Falcon Storage Expansion

Transportation Memorandum

Please add PCD File No. MS232
& PPR2232

RE: Falcon Storage Expansion
Transportation Memorandum
El Paso County, CO
LSC #S214430

SHEET
SDP1.1

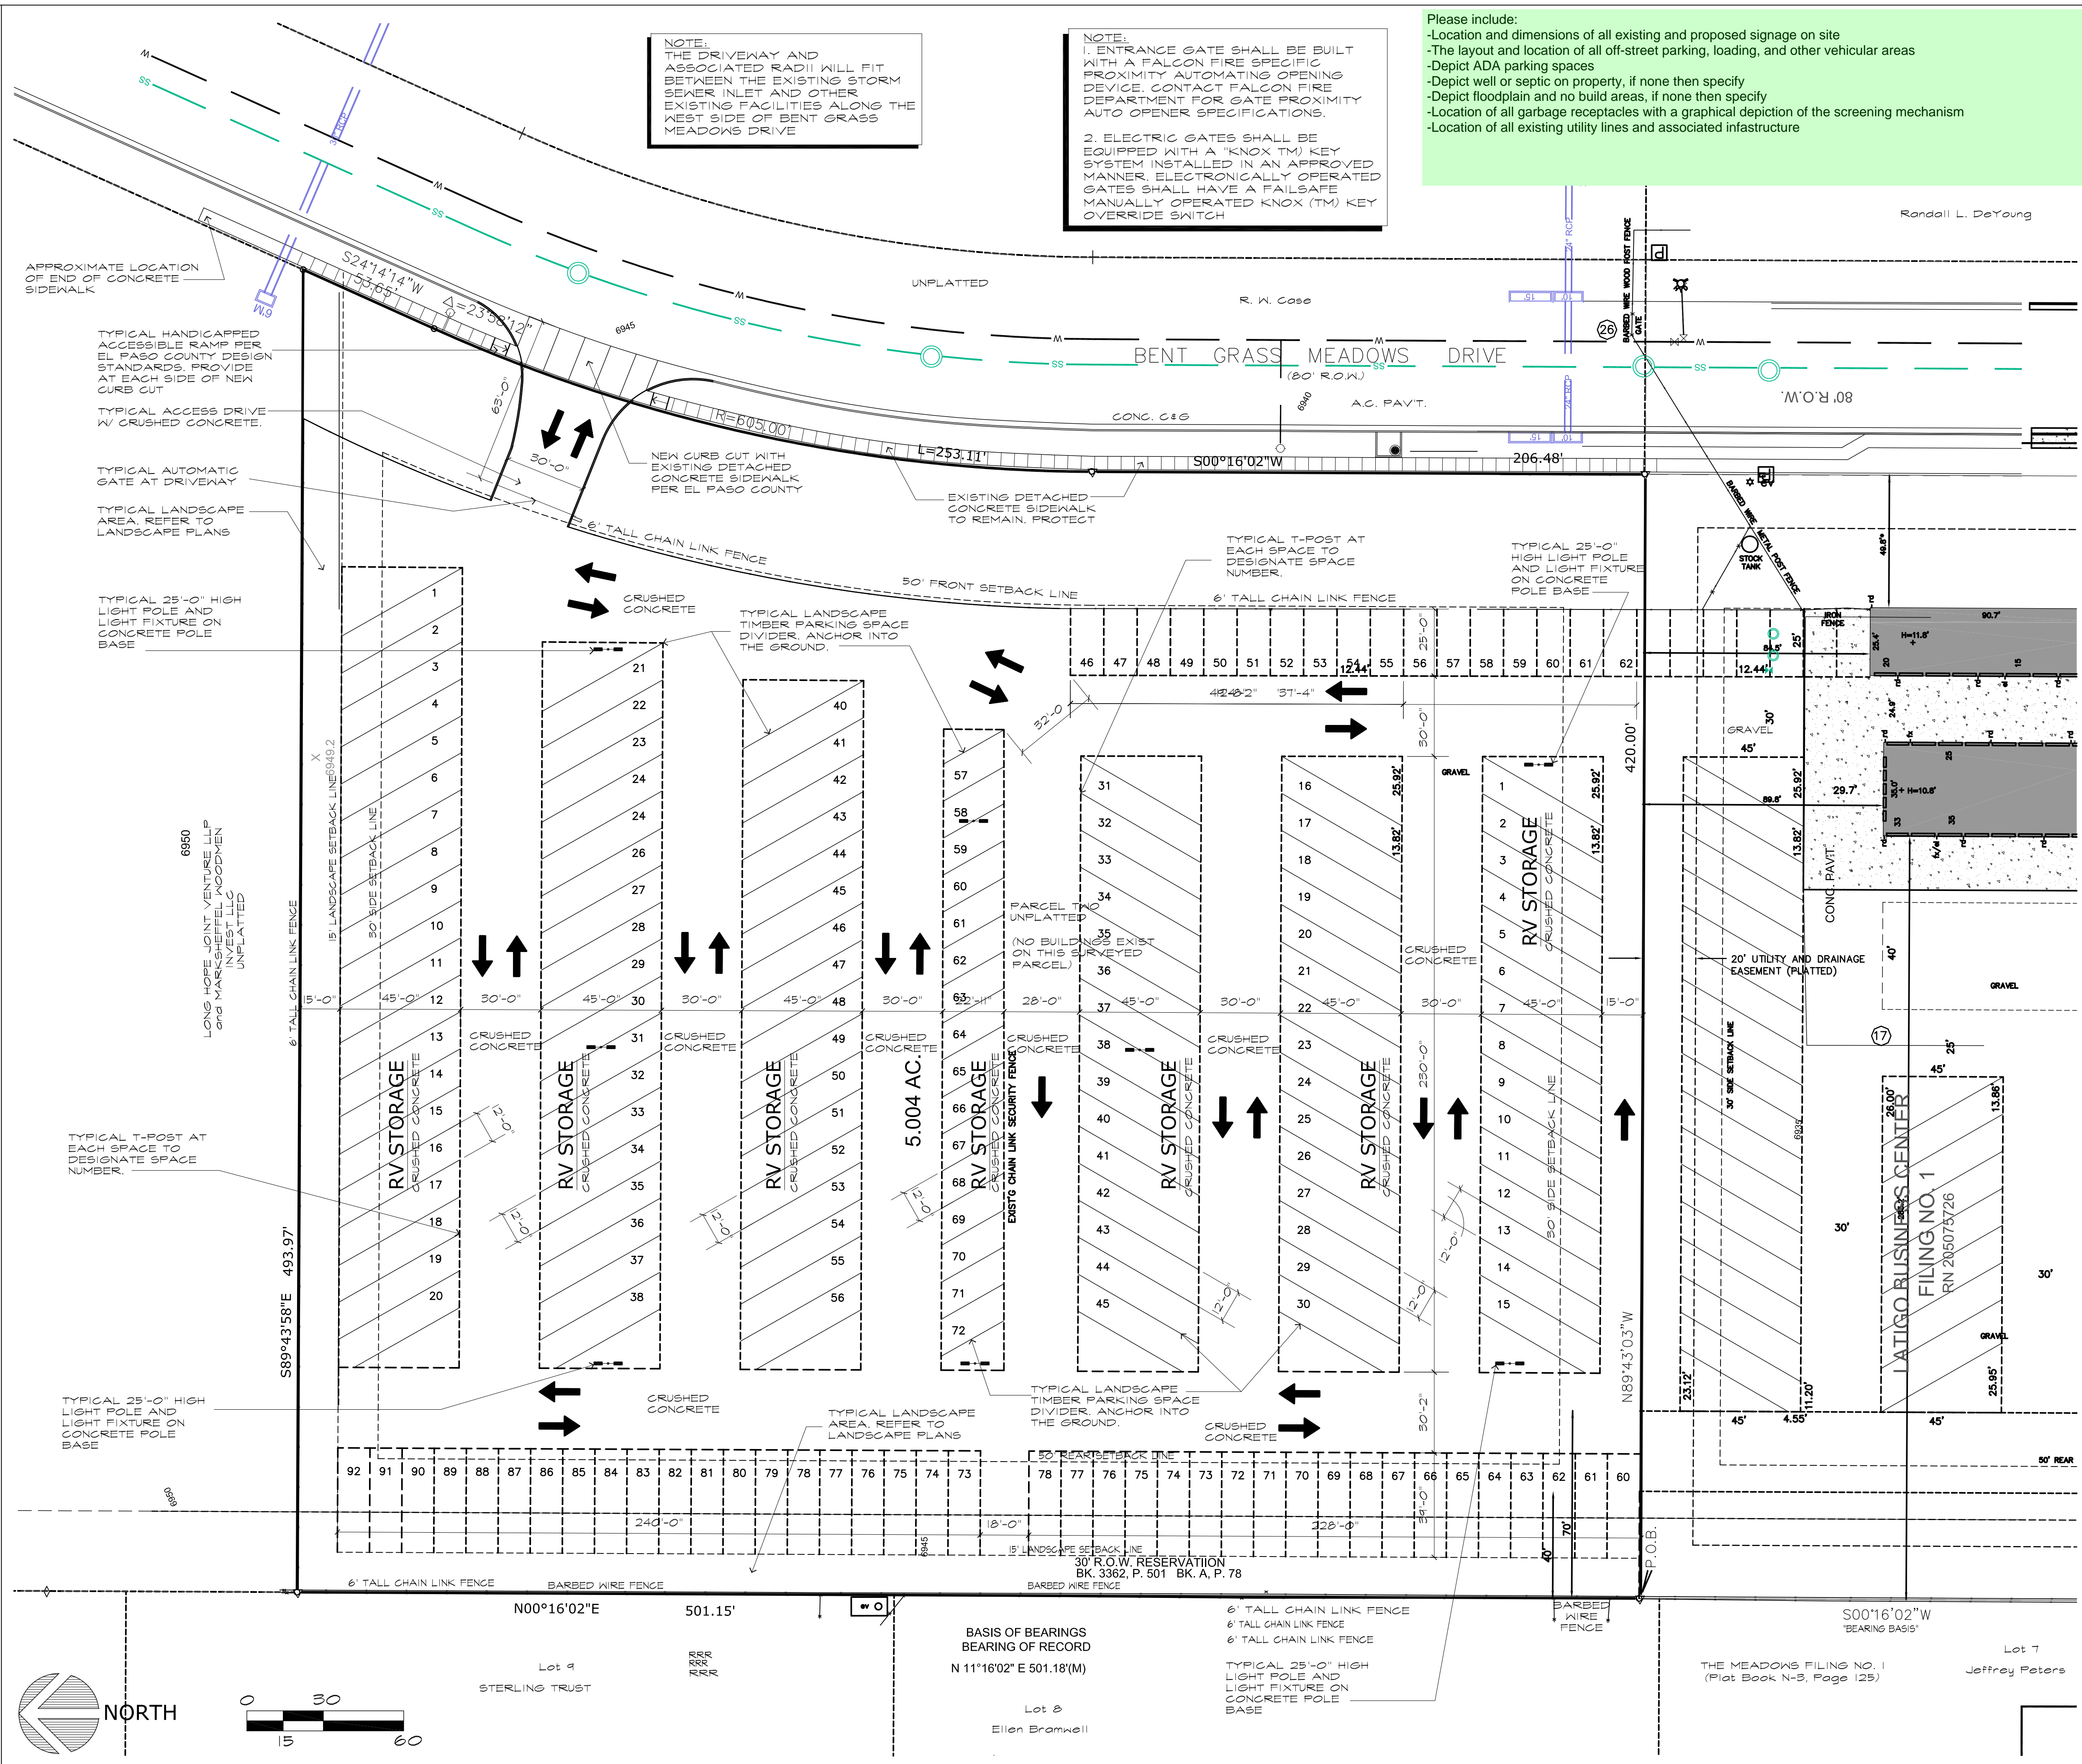
only a single access is proposed on the most recent site development plan. Revise accordingly.

revise accordingly as a single new access point is provided. Please update throughout the narrative.

Please update the site plan to match the current proposed plan showing a single new access point
